## MEMORANDUM

**TO:** Jean Fraser, Planner  
**FROM:** David Senus, PE  
**DATE:** March 17, 2016  
**RE:** 31 Fore Street, Final Level III Site Plan Application & Response to Comments

Woodard & Curran has reviewed the response to comments and final Level III Site Plan Application submittal for the proposed 4-unit condominium development at 31 Fore Street in Portland, Maine. The project involves the demolition of an existing house structure and the construction of a 4-unit condominium building with ground level parking below the units.

BACKWATER VALVE ASSEMBLY

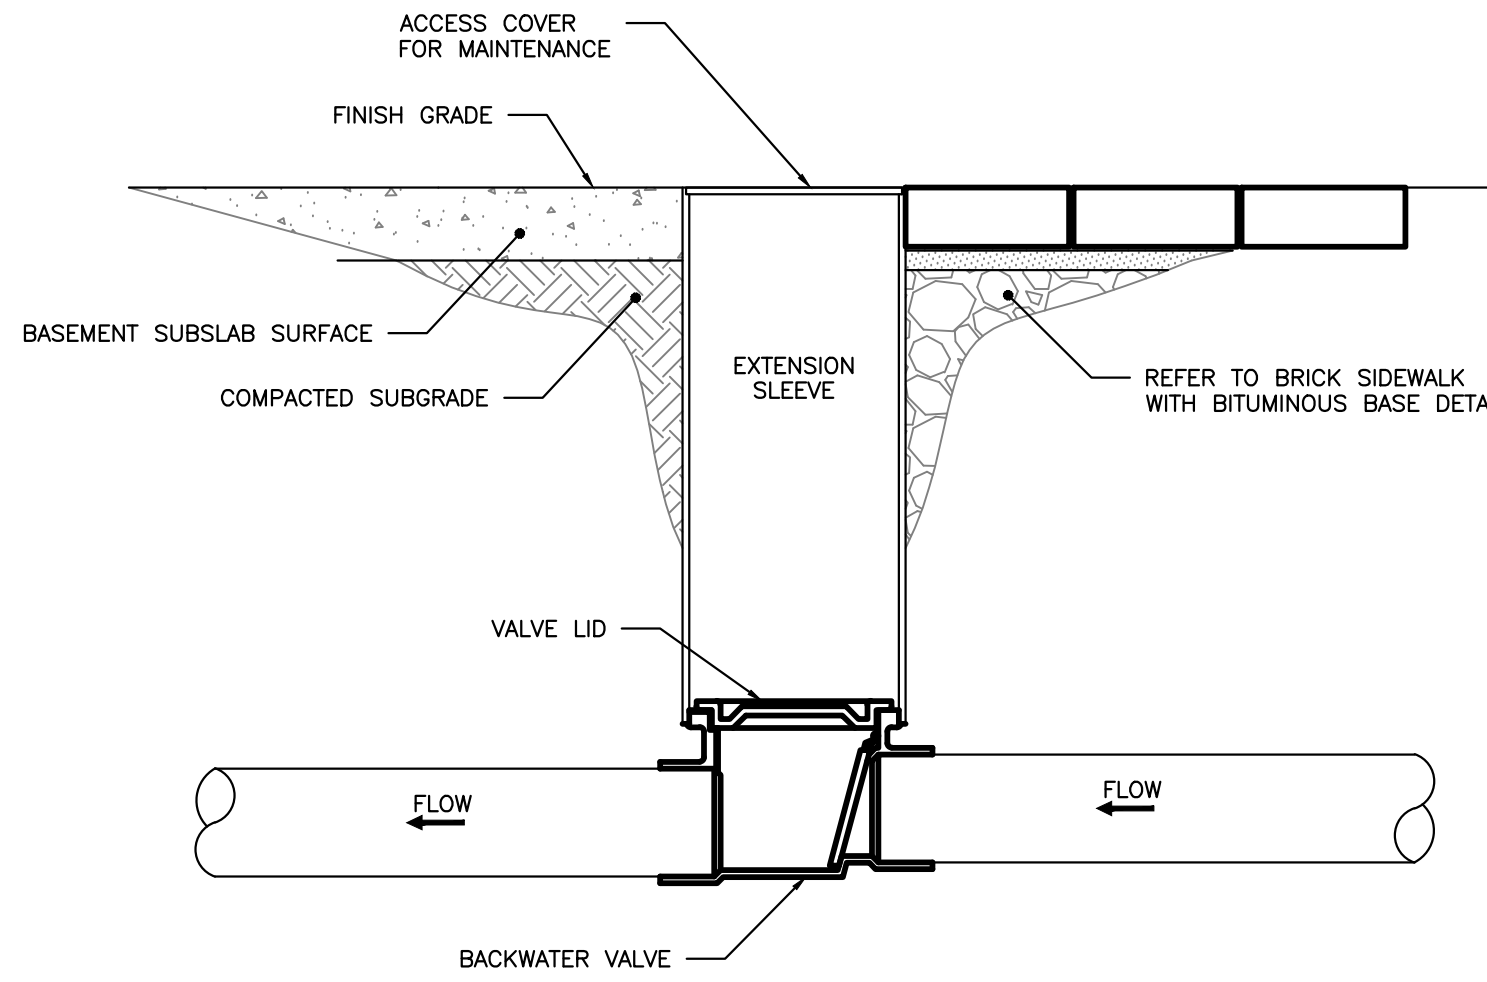
1. The sewer back water valve is shown within the City Right-of-Way, which is not standard practice for the City of Portland. The location of this valve will need to be reviewed by the Department of Public Works. The valve is located within the driveway of the proposed building; however the detail for the valve riser does not appear to be designed to receive vehicle loads.
2. All other review comments from the Woodard & Curran memorandum dated January 25, 2016 have been adequately addressed.
